**From:** Stella Agagiotis <Stella.Agagiotis@randwick.nsw.gov.au>  
**Sent:** Wednesday, 14 January 2026 2:58 PM  
**To:** Anson Tong  
**Cc:** David Appleby  
**Subject:** RE: Homes NS Fitzgerald Ave :Modification 1 - Design development and building compliance(SSD-71454960-Mod-1)- Reminder of Due Date for Response to Planner

Following our review of the design modifications yesterday we confirm that the changes to setbacks, building heights and planter boxes are generally minor and we raise no issues.

T12 *Cupaniopsis anacardioides*

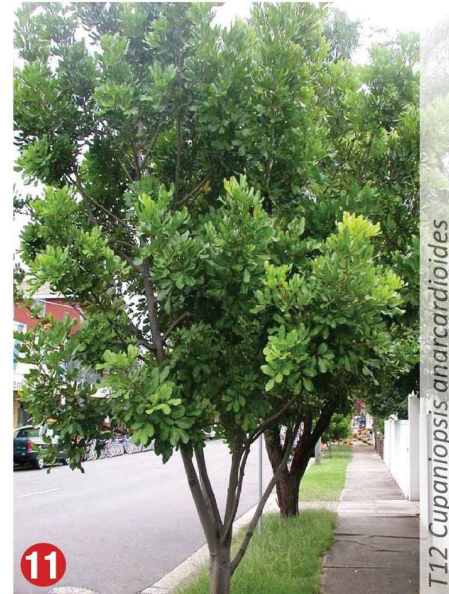
Please ensure the applicant is advised that Tuckeroo's are no longer to be planted in the Maroubra/Malabar/Matraville areas. This species has become problematic given prolific self-seeding, which has seen them invade sensitive areas such as the Malabar headland, National Park. This species has been removed from the most recent revision of our Street Tree Masterplan for this reason.

Therefore, please ensure that this species is substituted with an alternative native coastal tree.

1. Deep soil calculations adjusted to reflect general arrangement changes

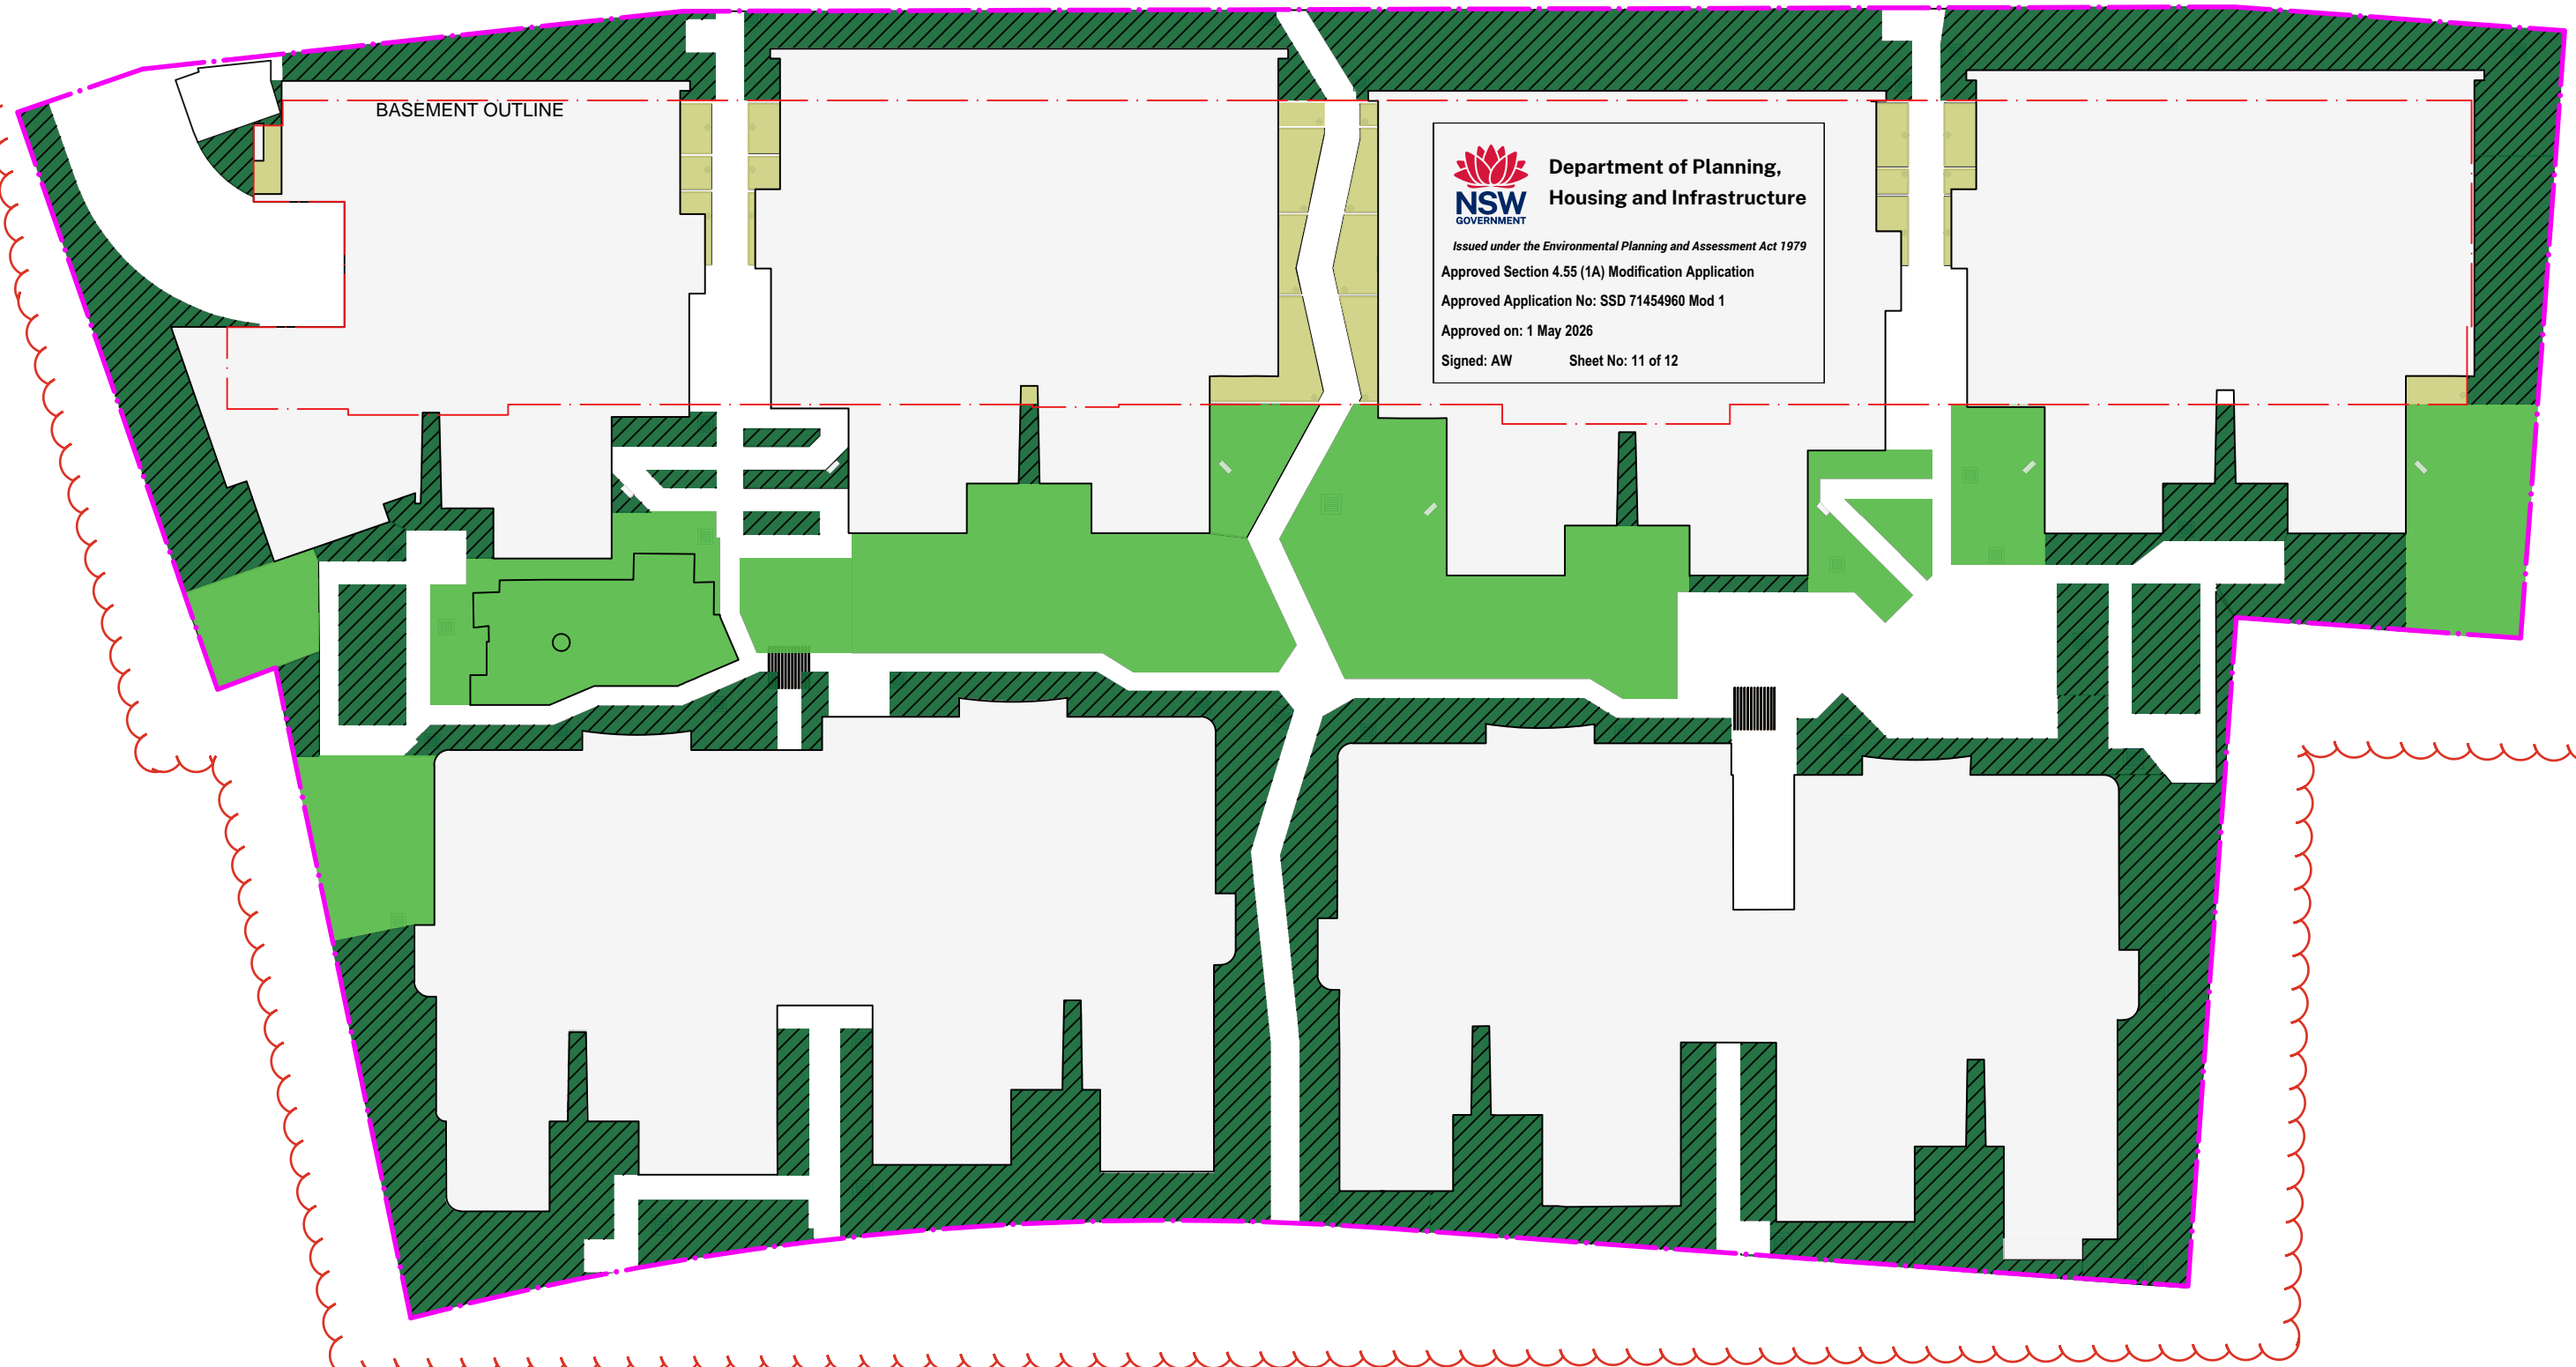
Council requests consideration of increasing deep soil zones where possible, to support tree planting, provide shade and enhance microclimatic cooling. While the proposed 10.5% of site area is compliant, it is considered insufficient to achieve long term environmental sustainability benefits for the site. The comment in Section 6.9 *Apartment Design Guide Compliance* should be clarified in reference to the deep soil provision across the entire site.
